CITY OF ALBUQUERQUE

**RE: Nuestros Valores Charter High School
Grading Plan
Stamp Date: 4/28/17
Hydrology File: L10D007**

Based upon the information provided in your submittal received 5/9/2017, the Grading Plan **is not** approved for Building and Grading Permit. The following comments need to be addressed for approval of the above referenced project:

C102

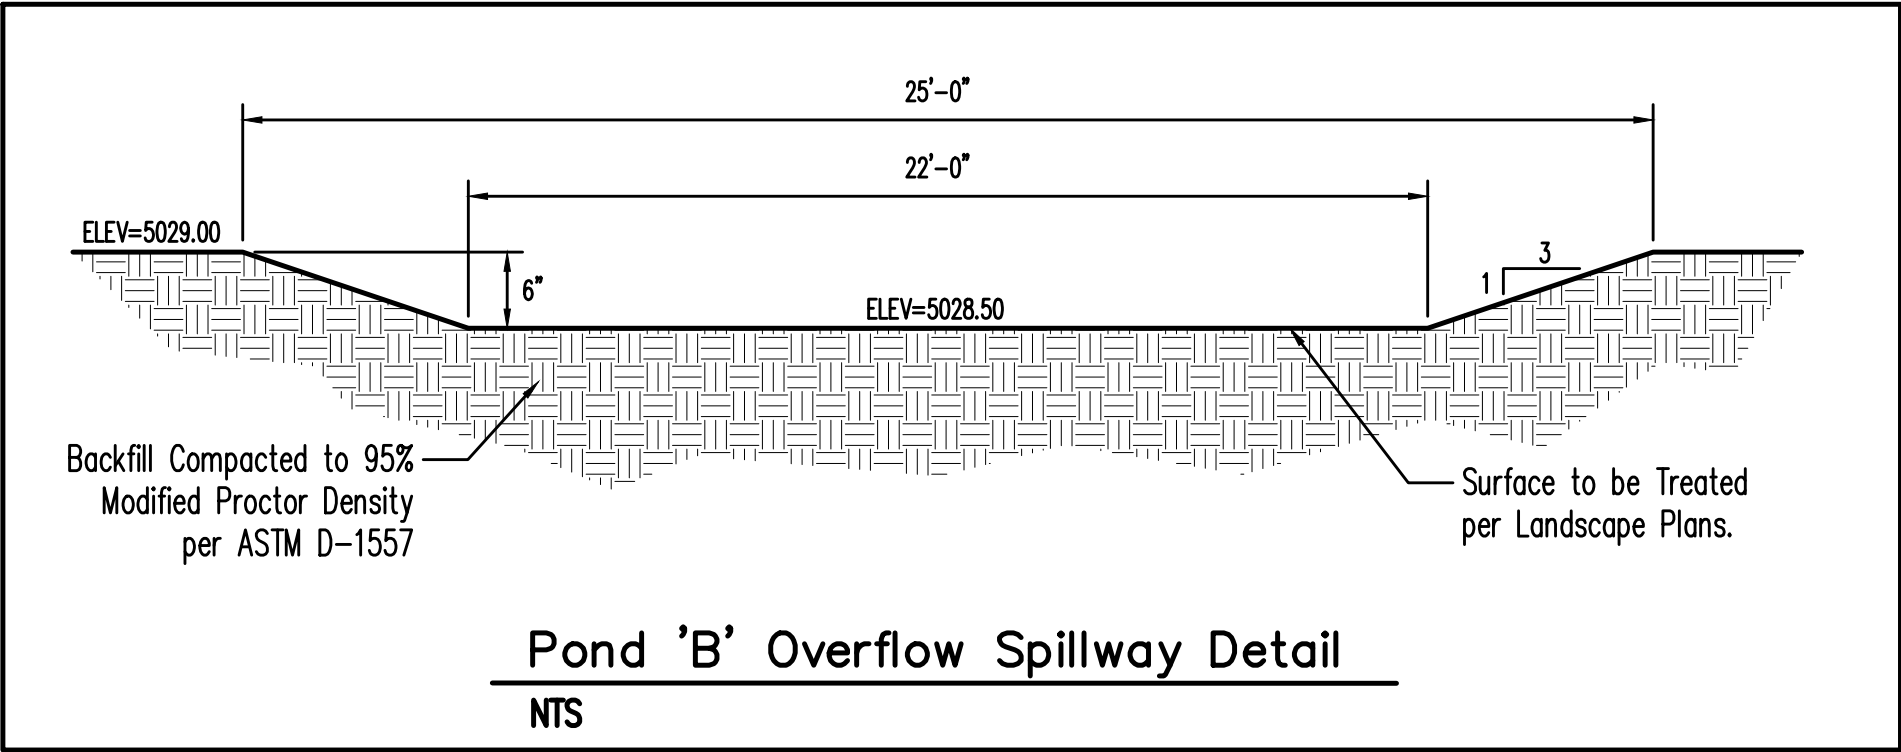
1. On C101, please provide benchmark information.
2. On C102, under the Proposed Hydrologic Conditions the ponds are stated to be designed for the 100-yr, 6 hr storm. Per the CoA DPM, the retention ponds are to be sized for the 100-yr, 10 day storm. Please revise.

3. Please provide the AHYMO routing output for the retention pond system.
4. On C102, according to the drainage calculations provided, the required 100-yr, 10 day storm volume for Pond A is 10,802 CF and not 6,810 CF. Pond B required volume is 9,832 CF and not 6,382. Please correct the required 100-yr, 10 day storm volume for Ponds A & B.

5. On C101 & C102, based on the above comment, Pond A & B are currently sized too small to handle the 100-yr, 10 day storm. Please resize both ponds to meet the required volume.

6. On C102, Please provide an overall drainage basin map for the three basins along with the ponds and the drainage flow arrows.
